CITY OF ALBUQUERQUE
Comments from
Planning Department
Conceptual Grading & Drainage Plan
and Drainage Report
Sonata Trails Unit 4 Apartments
Prepared By
RESPEC, Dated June 2020

Based on the submittal received by the Planning Department on 5/21/20, RESPEC received the following comments below from Renée C. Brissette, P.E., CFM, Senior Engineer, Planning Department. Our responses to the comments are provided below each comment in *italics* font.

EXHIBIT 2 PROPOSED BASINS

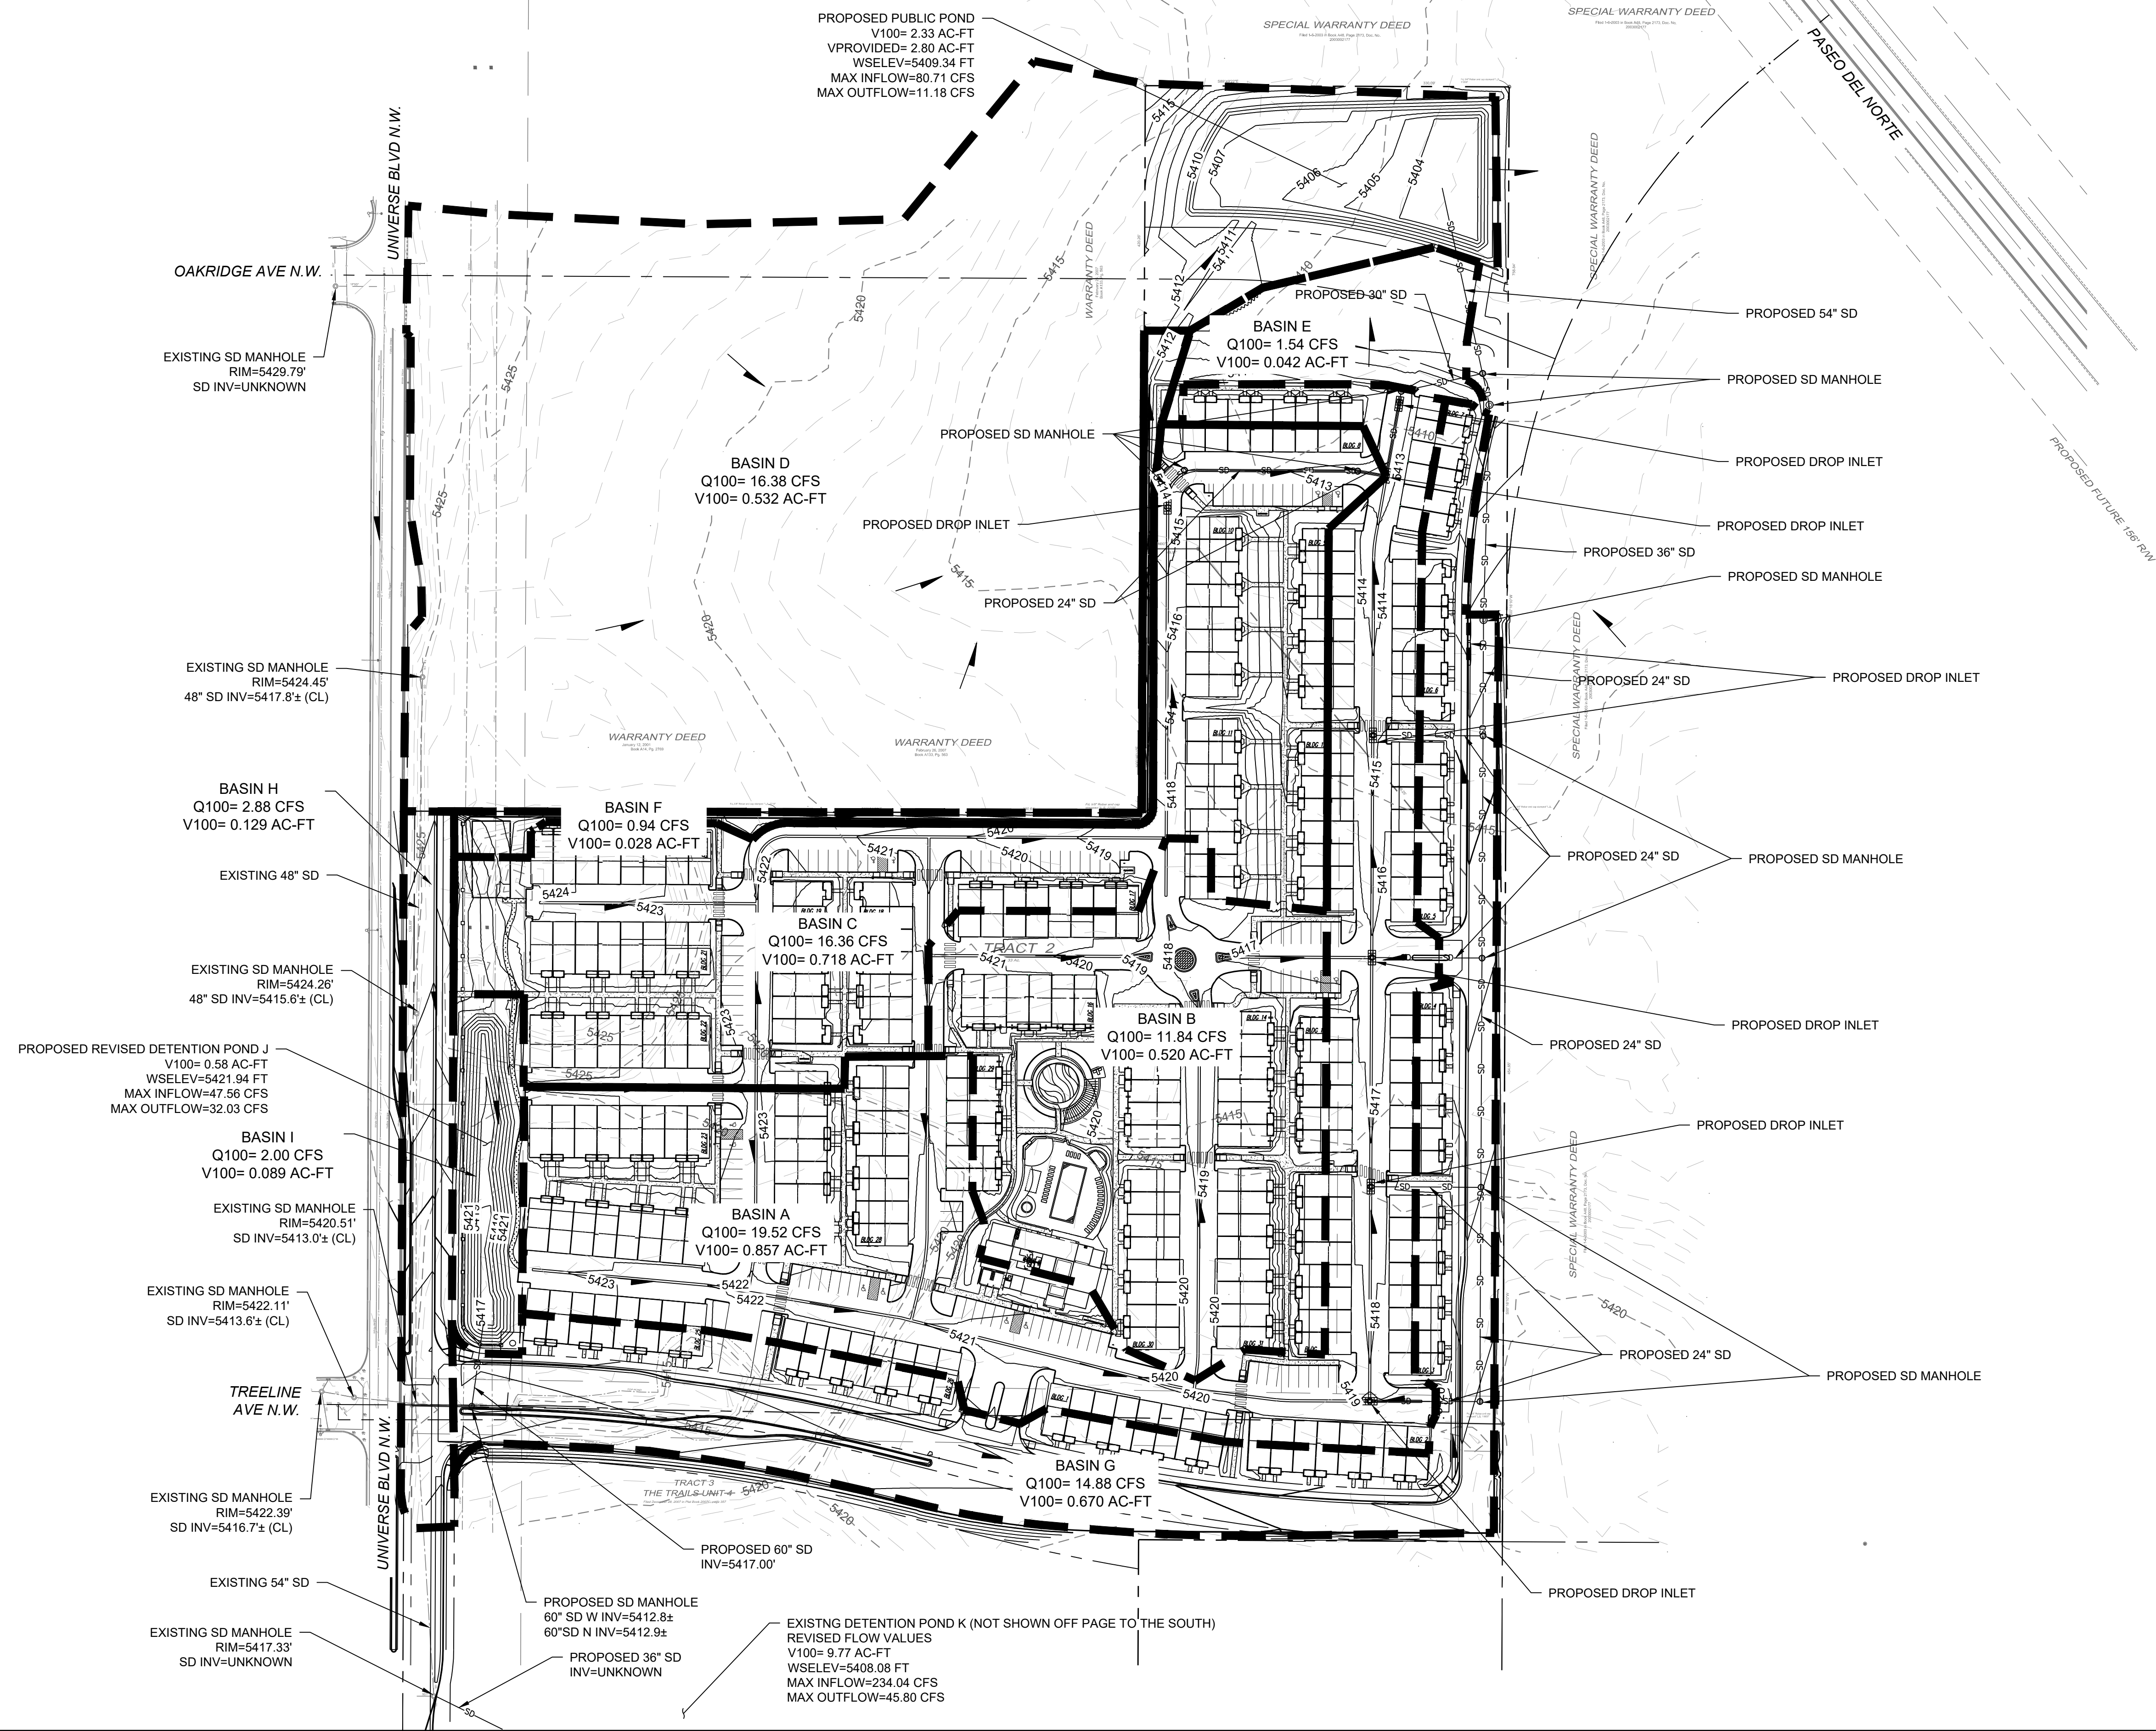
3. Please provide a conceptual storm drain layout with pipe sizes.

Conceptual storm drain layout and sizes provided, see Exhibit 2 Proposed Basins.

EXHIBIT 1 EXISTING BASIN B

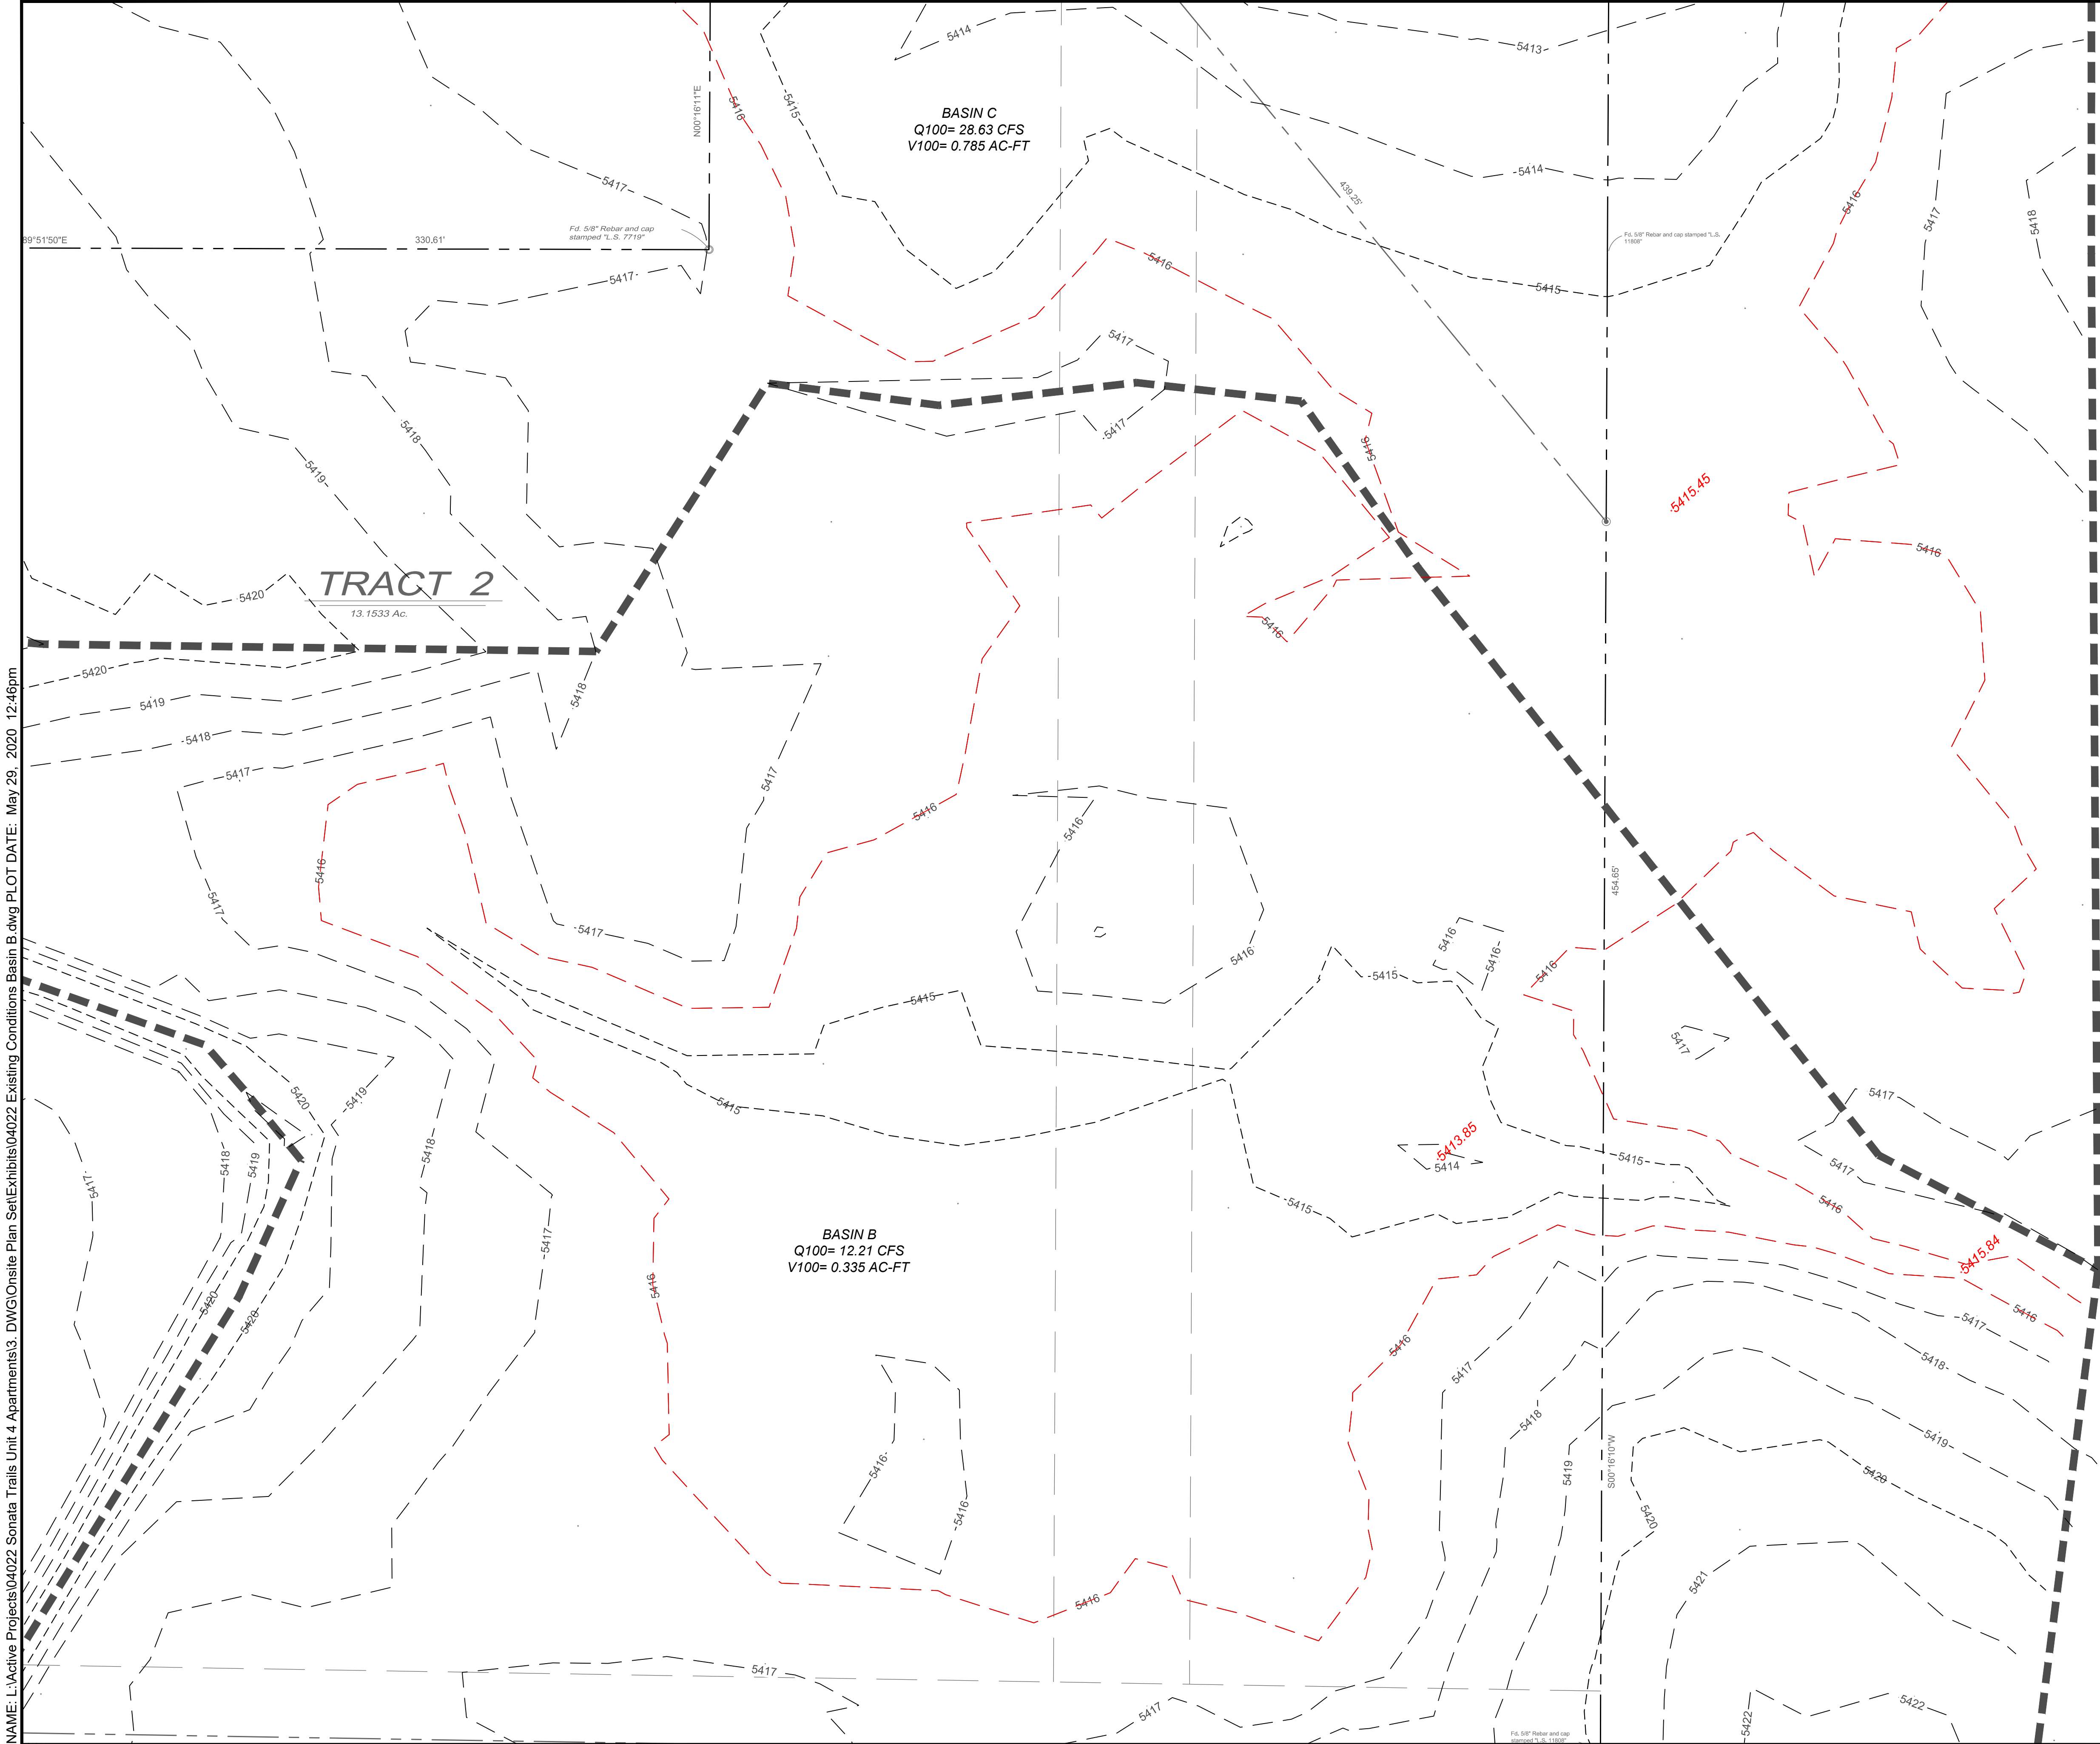
6. In reviewing Existing Basin B with provided existing contours and the City's LiDAR information, the existing Basin B does not drain to existing Basin C to the northeast but rather is drains to the southeast. Therefore the existing 12.21 cfs drains to the southeast, Please review and revised.

7. Since existing Basin B drains to the southeast, existing Basin C (28.63 cfs) and ½ of existing Basin A (3.44 cfs) drains to the northeast for a total of 32.07 cfs. Please review and revise.

Per your concurrence via email dated June 3, 2020, the existing Basin B drainage discharges to the northeast . Therefore, we propose no change to our drainage report.

Please refer to response to comment #6.
